Mr & Mrs Harris
Paul's House
254 Church Lane
Lyminster
BN17 7QJ

Your Ref: OWPC22109
Our Ref: LY/4/19/HH 08-03-2019
Please ask for:
Zac Denton

Proposed first floor side extension, single storey rear extension to existing dwelling and summer house within garden. This application affects the character and appearance of the Lyminster Conservation Area and affects the setting of a Listed Building.

253 Church Lane Lyminster

PROPOSED SIDE ELEVATION
(EAST)
TAKEN THROUGH NEIGHBOURS' PROPERTY

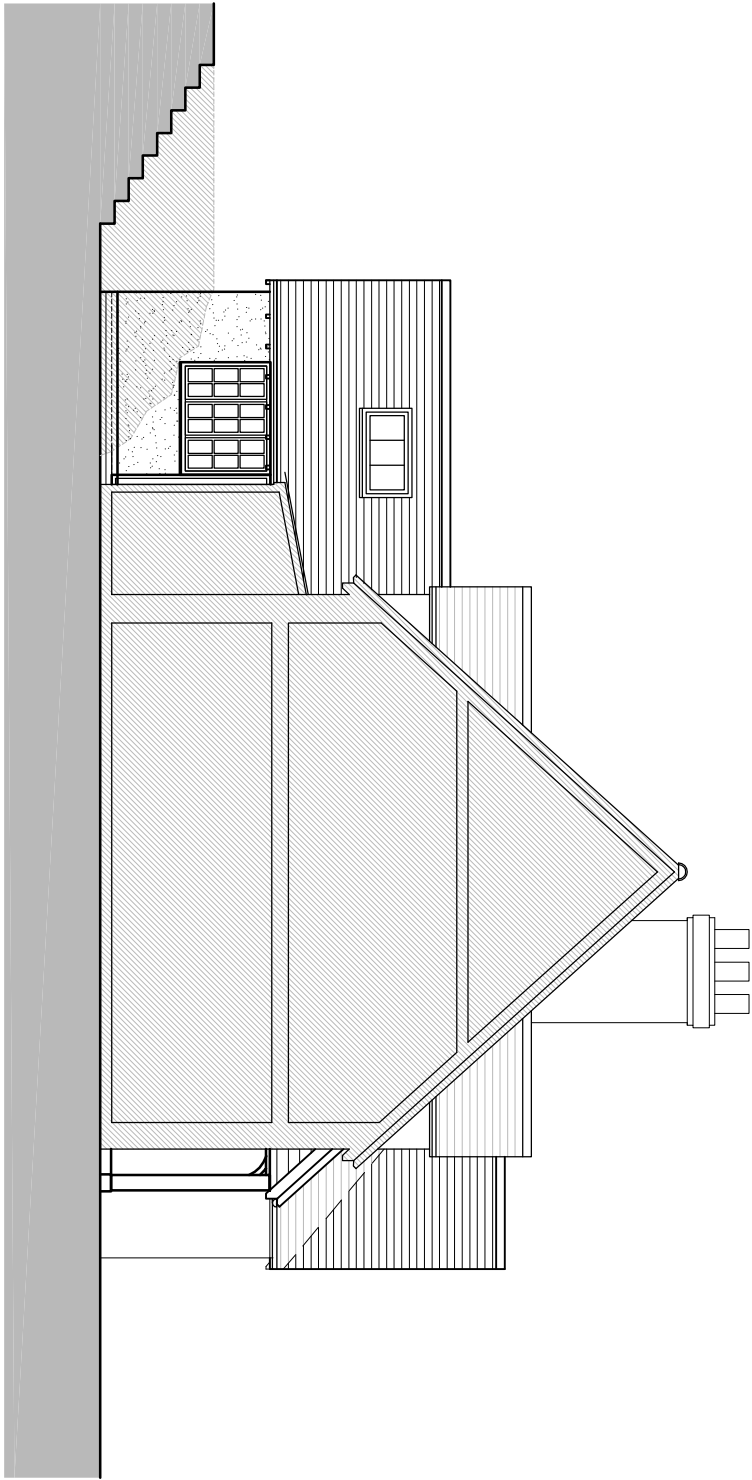
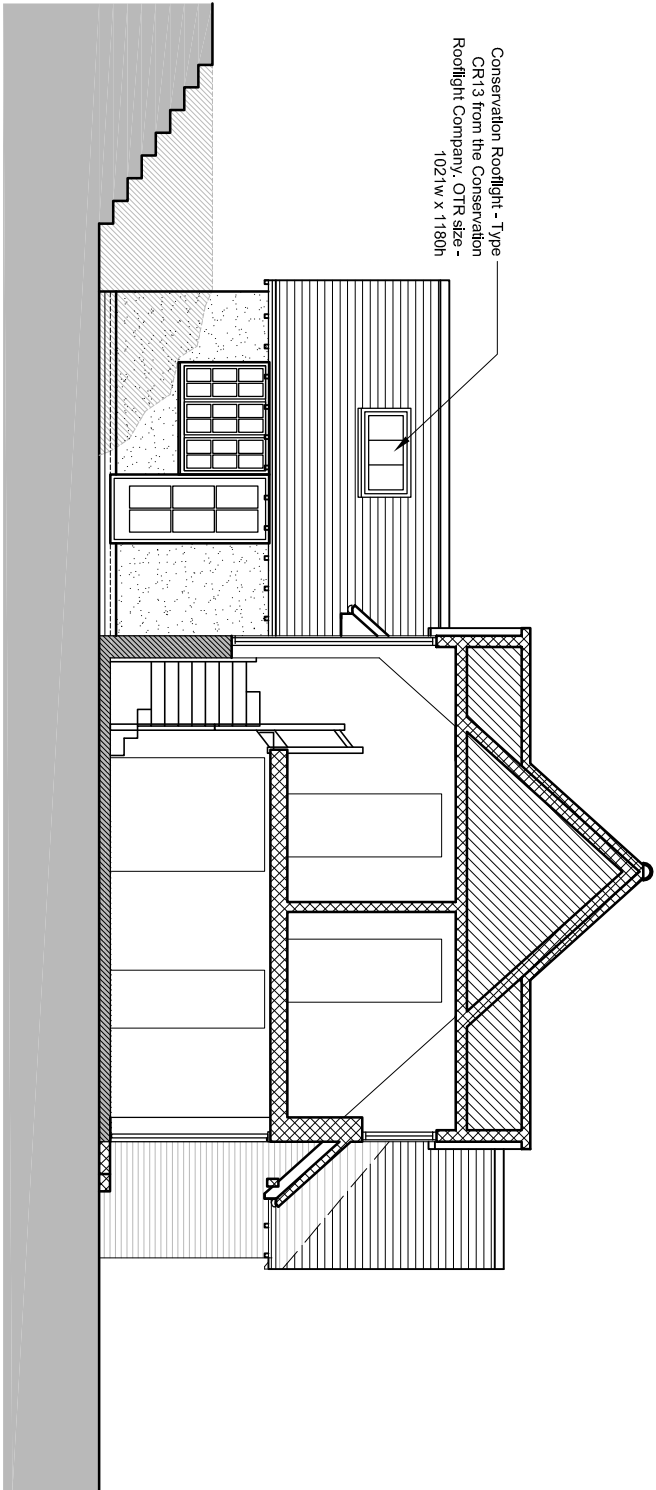
Furthermore, the Conservation Area Management Plan (note 3.45) refers to the importance of spacial gaps between buildings. These gaps often form an important part of the character of the conservation area. Approving Mr & Mrs Messenger's plans will remove a very important spacial quality between our two houses. Indeed, we agree with Mr David Hall in his objection which states that this proposal will dominate the host property and create a 'terrace effect' on this set of historic cottages.

and Lyminster will also reduce the light entering the neighbouring property of 254 Church Lane. It is felt that the half-hip roof will not compensate enough and the reduction of light will have a detrimental effect on the quality of our life. We also feel that a two-storey extension will be an invasion of our privacy as Mr & Mrs Messenger and family will be able to look directly into our garden from their first storey extension.

Drawing Title: PROPOSED ELEVATIONS

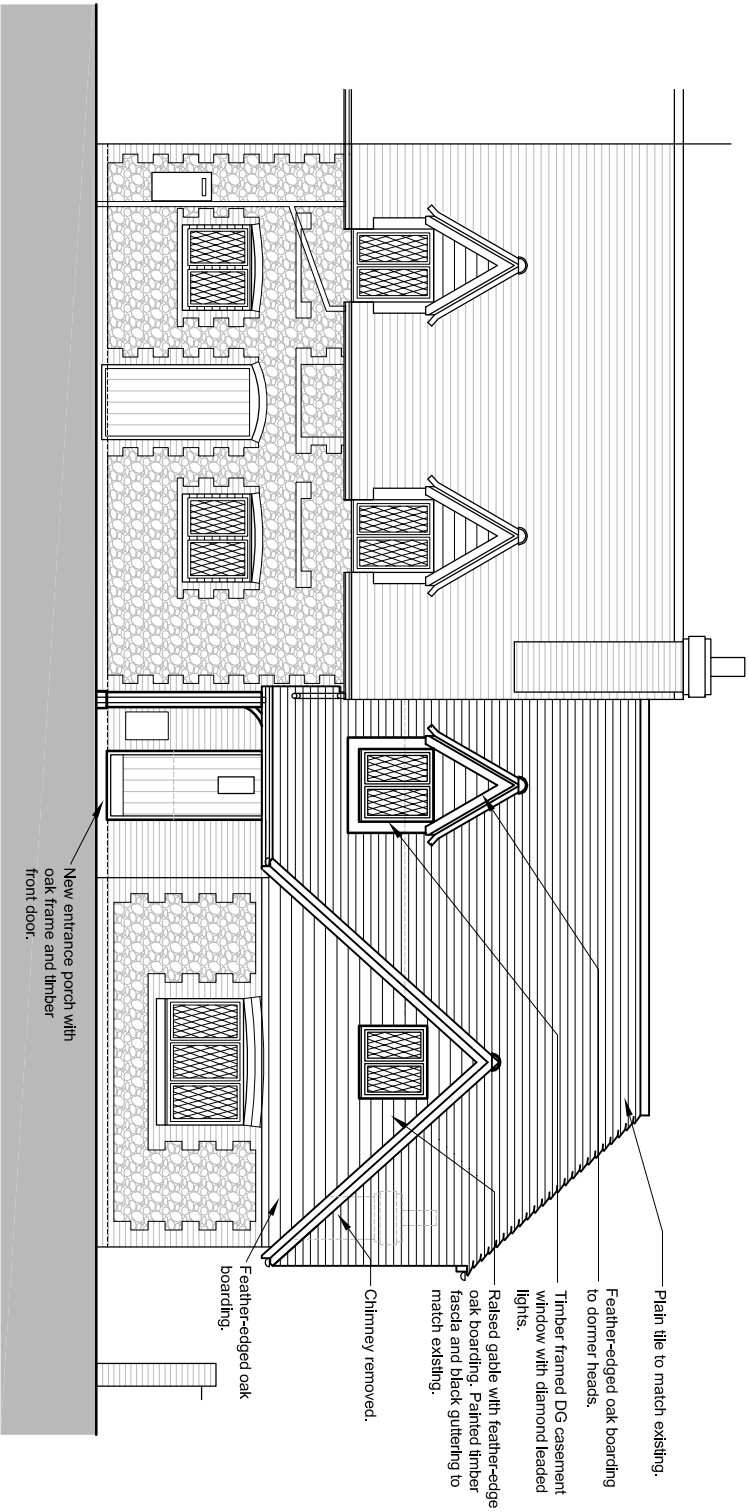
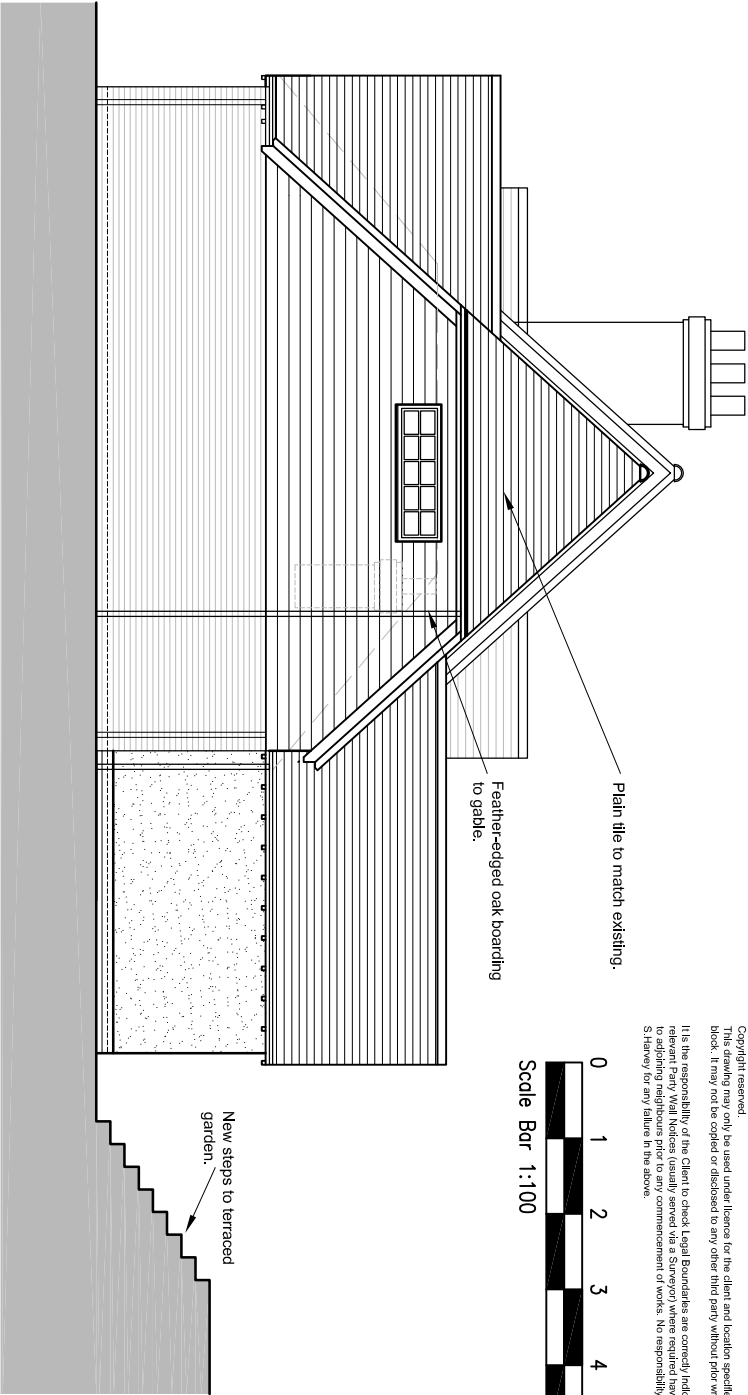
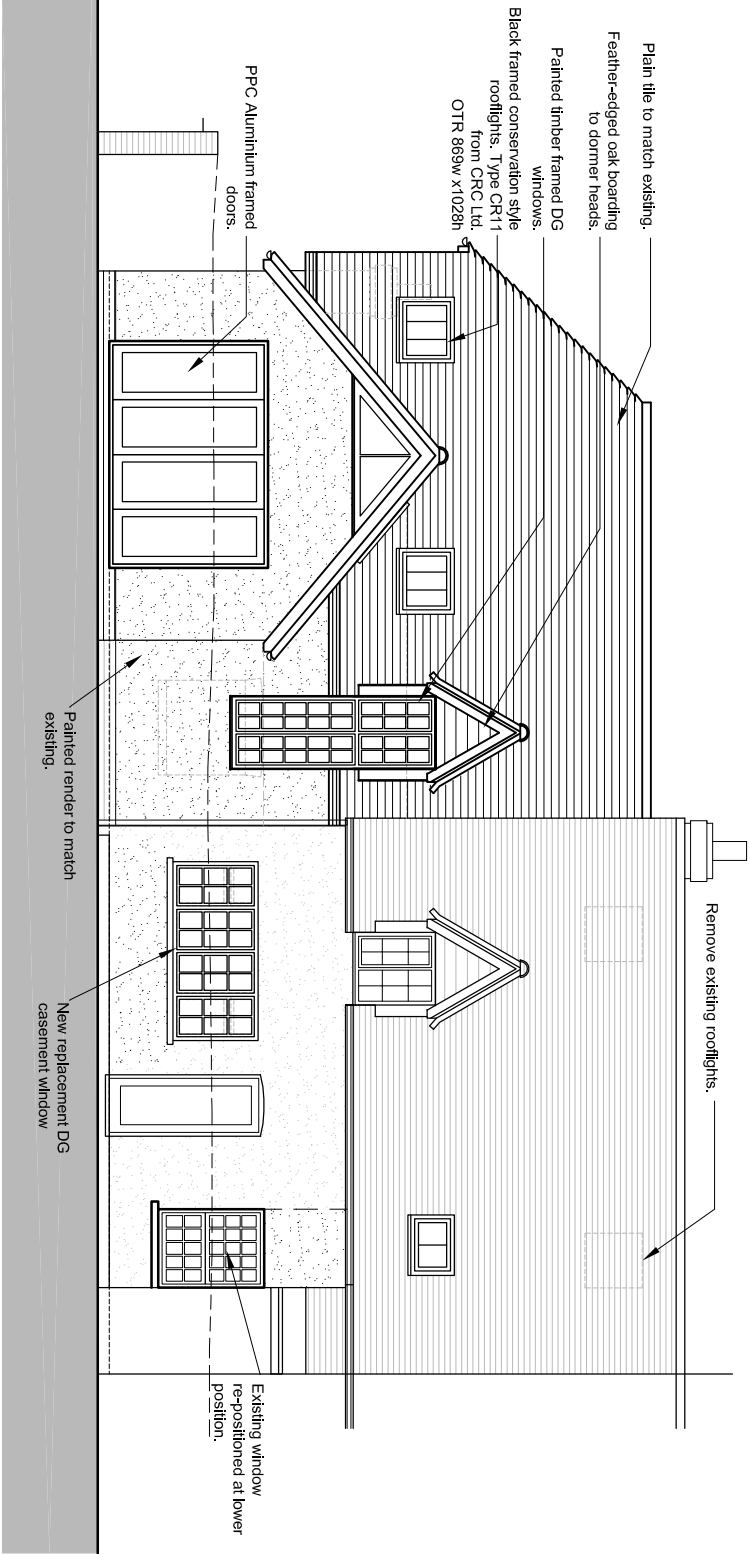
The first-floor extension, as well as causing an alteration to the character of Church Lane
